The Drovers Solar Farm

Appendix 7.1: Consultation and Legislation, Planning Policy and Guidance (Clean)

PINS reference: EN0110013

Document reference: APP/6.4.1 (Revision 1)

DRAWING TITLE:
Figure 2-3 Field Numbering

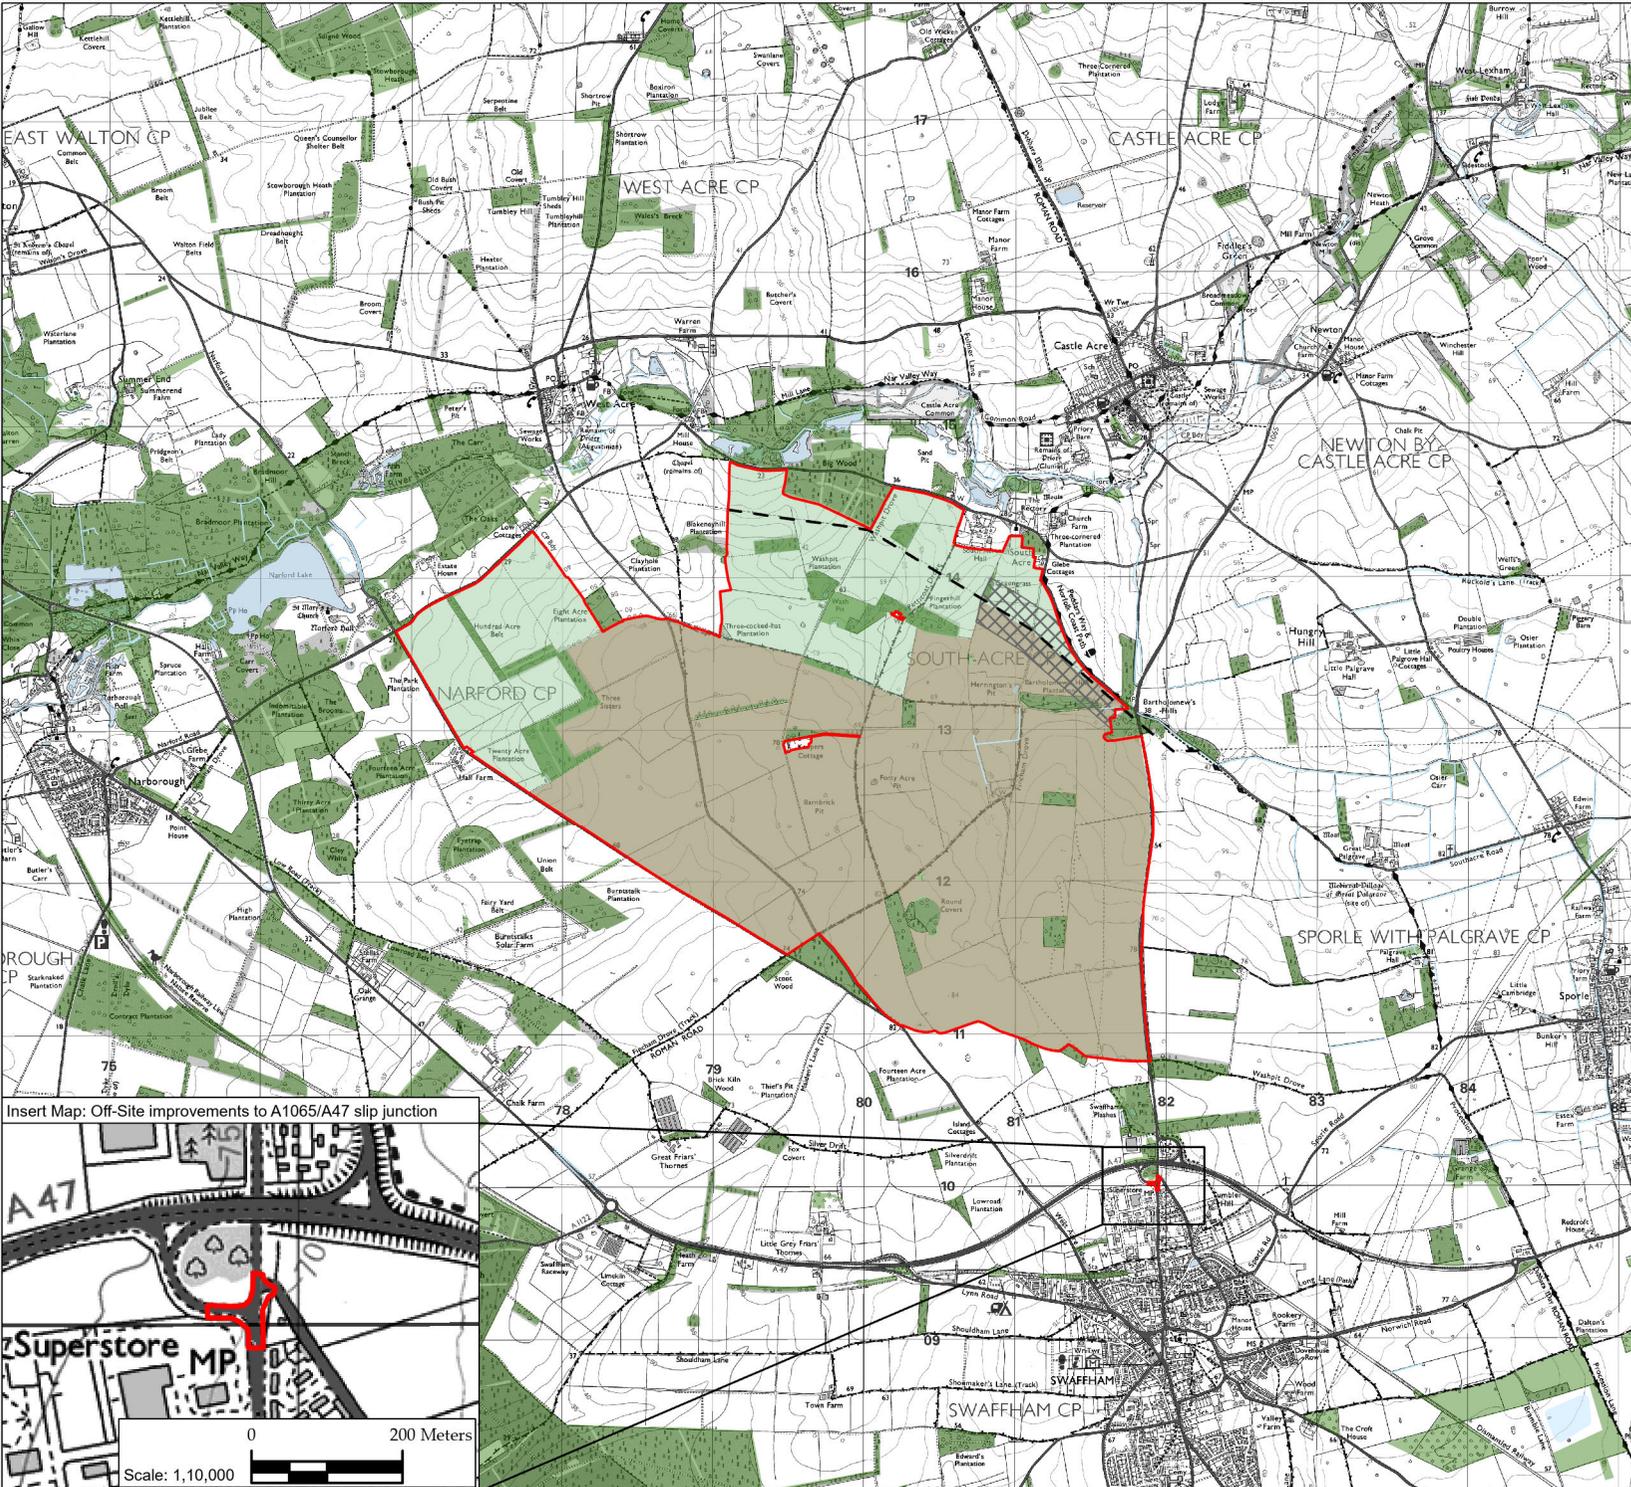
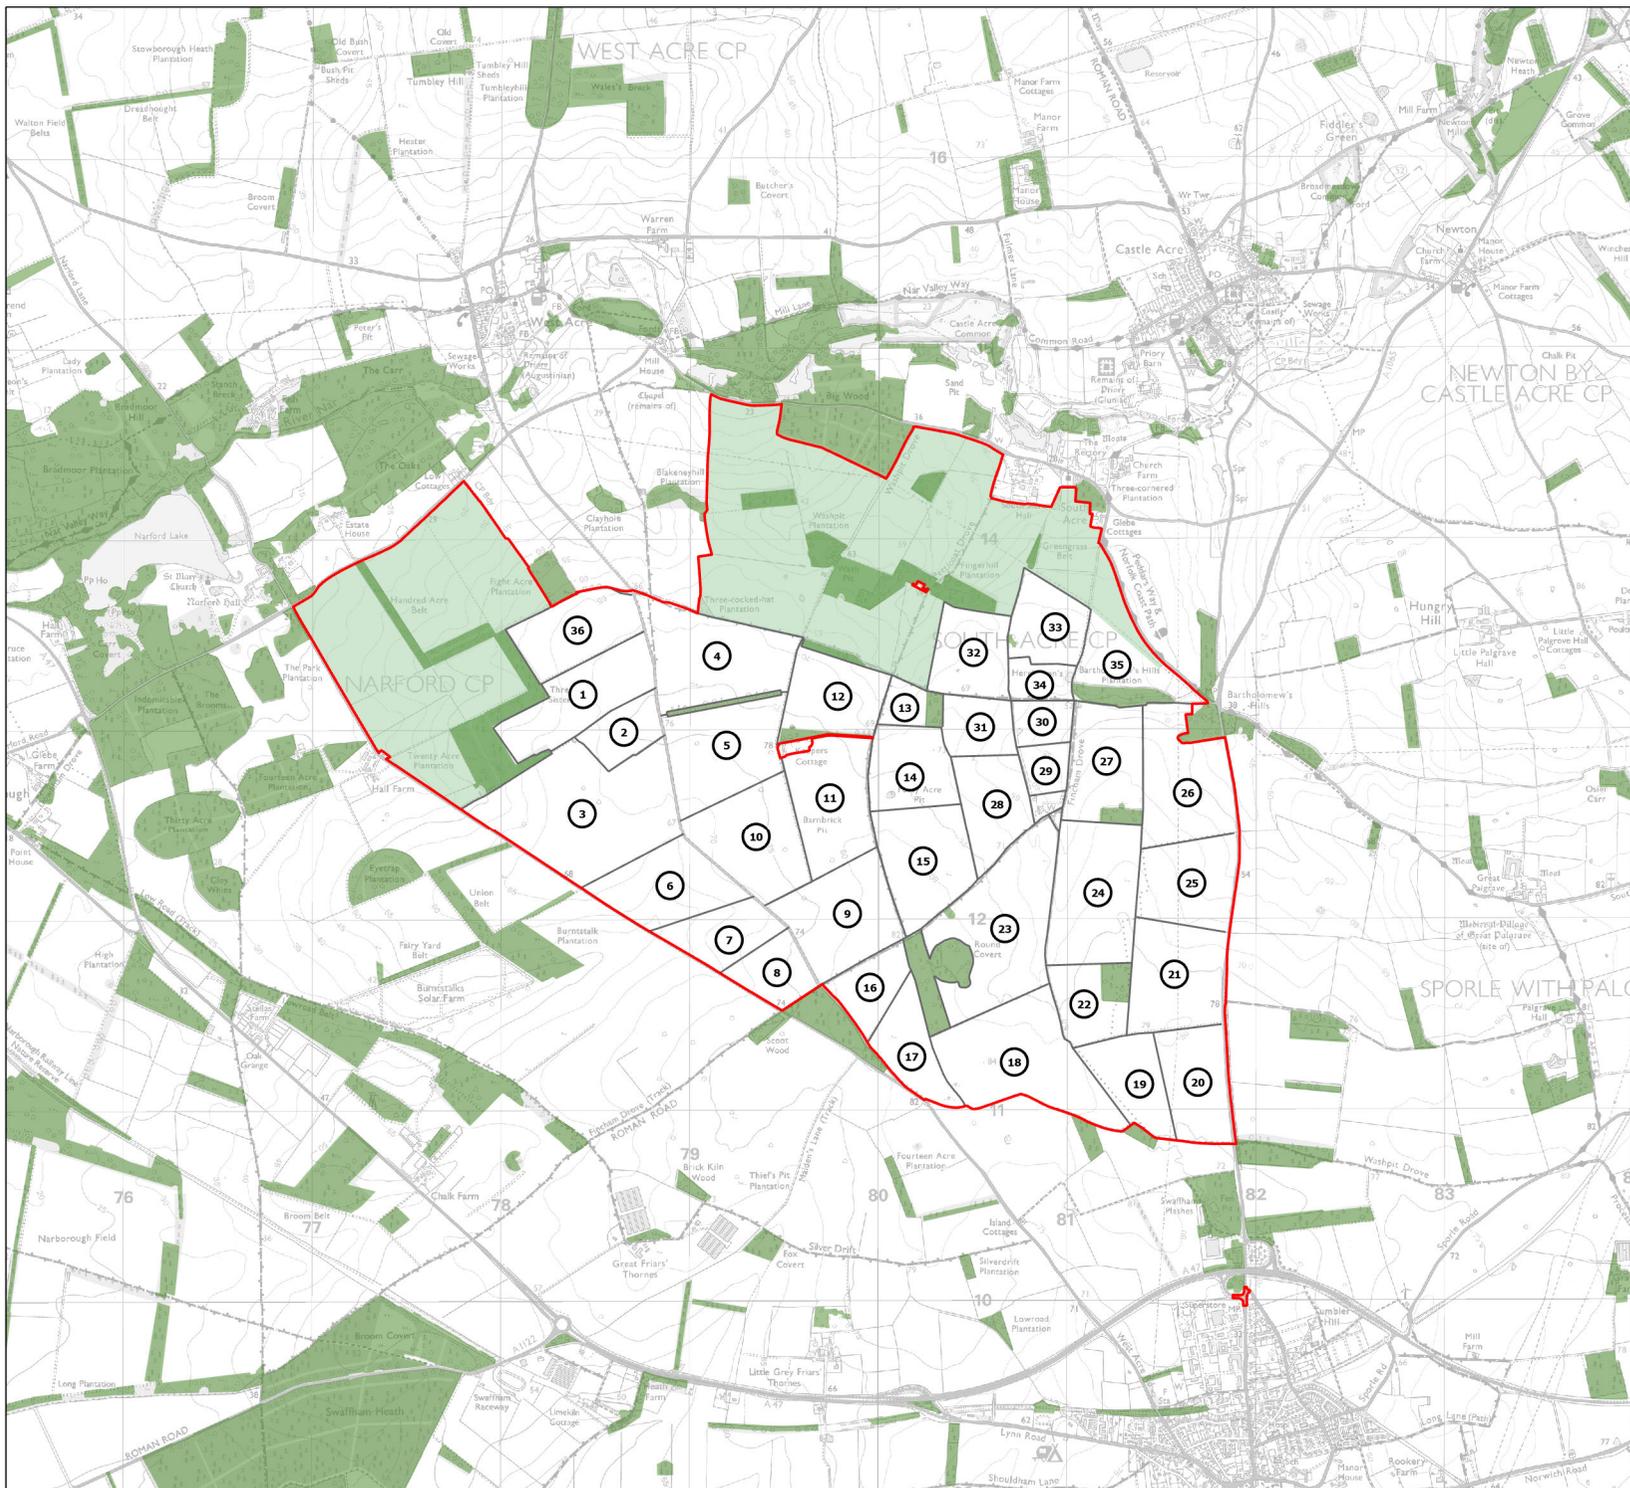
Environment Agency EIA Scoping Opinion, December 2024	Site Boundary: "The EIA scoping report should consider all potential impacts within and adjacent to the Red Line Boundary or 'site boundary'. Currently the ecological surveys are restricted to land within the potential development boundary (Figure 2.3), not the whole site boundary. Land within the site boundary but out-with the	Noted. The Order limits have been refined throughout the design evolution of the Scheme and all land within the Order limits has been surveyed.	ES Appendix 7.2: Baseline Ecological Survey Report [APP/6.4]

<p>potential development area is labelled 'potential mitigation and enhancement area' (Figure 2.2, 2.3). This land also needs to be included in the scope of the Environmental Statement (ES) and appropriate ecological surveys must be carried out."</p>		
<p>Environment Agency EIA Scoping Opinion, December 2024</p>	<p>Non-statutory Designations: "...the following CWS" should be scoped into the assessment:</p> <ul style="list-style-type: none"> • Land Adjacent to the River Nar (895, 945, 902) • Narford Lake • Priory Meadow • Land West of Castle Acre • Mill House Lake 	<p>These non-statutory designations are assessed within ES Chapter 7: Ecology and Biodiversity [APP/6.2].</p>	<p>Section 7.8 of ES Chapter 7: Ecology and Biodiversity [APP/6.2].</p>
<p>Environment Agency EIA Scoping Opinion, December 2024</p>	<p>Protected Species and Biodiversity: "Impact assessment on mammals using the site should include assessment of the fencing which will be used to enclose the site, and the impact this has on excluding mammals from their range."</p>	<p>Specific consideration in regard to the potential impacts of proposed fencing on mammals is included within ES Chapter 7: Ecology and Biodiversity [APP/6.2].</p>	<p>Section 7.8 ES Chapter 7: Ecology and Biodiversity [APP/6.2].</p>
